**KIRKLEES METROPOLITAN COUNCIL
INVESTMENT & REGENERATION SERVICE**

DELEGATED DECISION TO DETERMINE PLANNING APPLICATIONS

Reference No:	2025/62/90861/E
Site Address:	Albion Inn, Knowler Hill, Millbridge, Liversedge, WF15 6DP
Description:	Erection of first floor extension to detached garage to create dwelling forming annex accommodation associated with Albion Inn, Knowler Hill, Millbridge, Liversedge, WF15 6DP (Listed Building)
Recommending Officer:	Edward Cheseldine

DECISION – Full Conditional Permission

Proposed Elevations

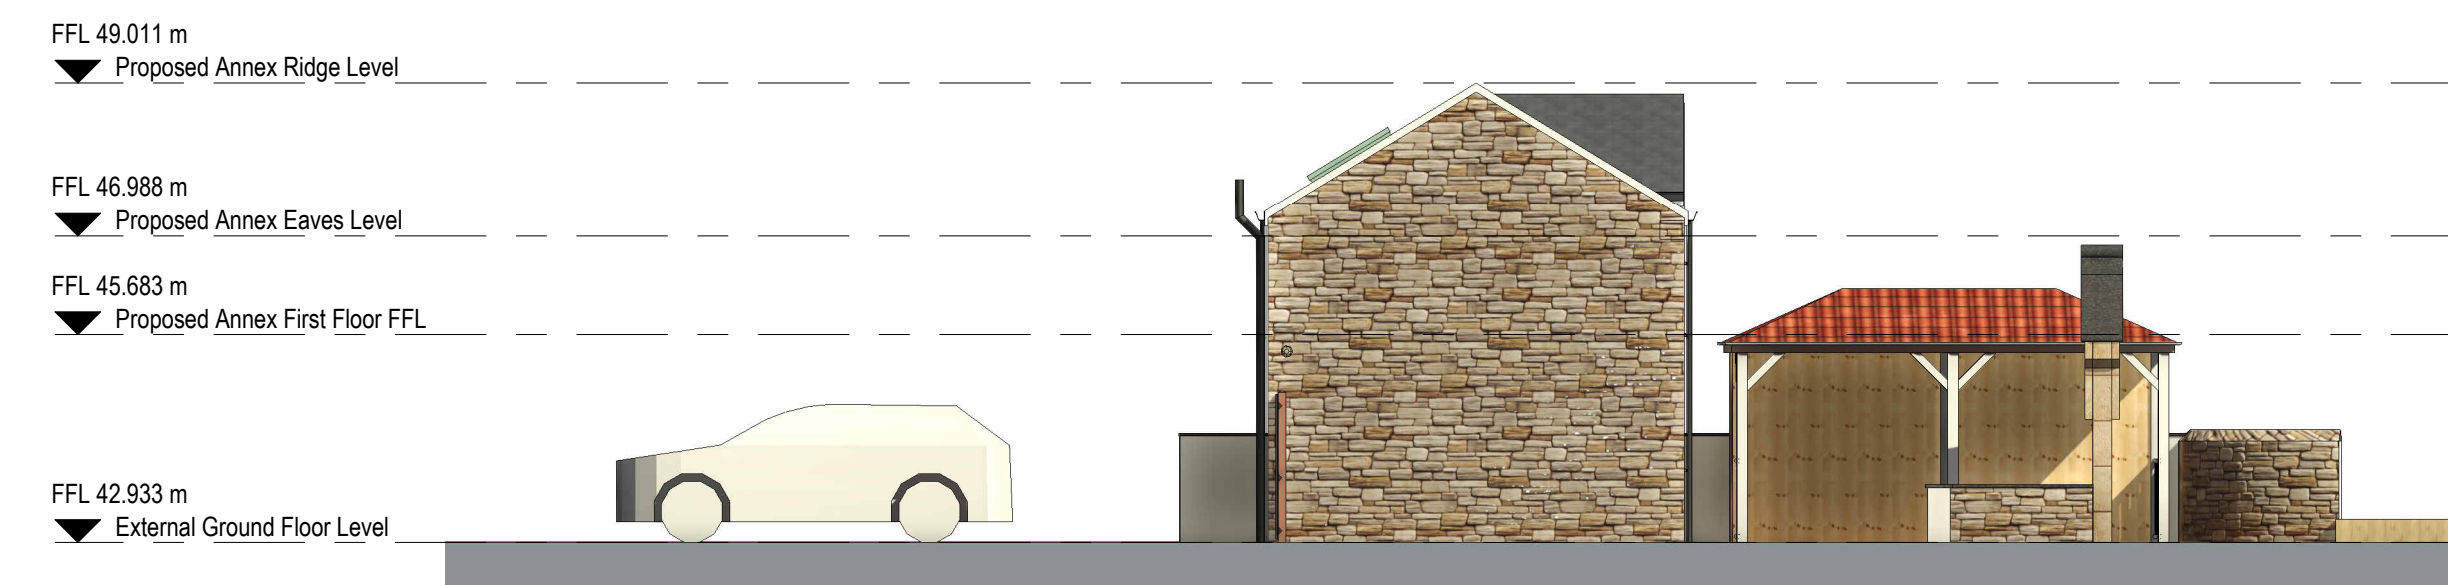
It was requested a stone lintel, or wooden timber beam was placed above the garage door to break up the vertical mass of the building. Amended plans were received to include stone lintels. Additional public consultation was not conducted due to the nature of the amendments. Neighbours would not be prejudiced by this decision and any comments received would be taken into account in the assessment of the application.

KC Conservation & Design – Informal consultation was undertaken. As the garage is a later addition to the curtilage of the listed building, modifications are acceptable. The design of the garage extension is subsidiary and subservient. It was recommended that a lintel be placed above the garage door to provide a visual break to the appearance of the building. Design amendments were received on 18 June 2025 to provide the visual breaking, therefore overcoming conservation concerns. Conditions were recommended that the water goods are black aluminium which will be set.

It was requested a stone lintel, or wooden timber beam was placed above the garage door to break up the vertical mass of the building. Amended plans were received to include stone lintels.
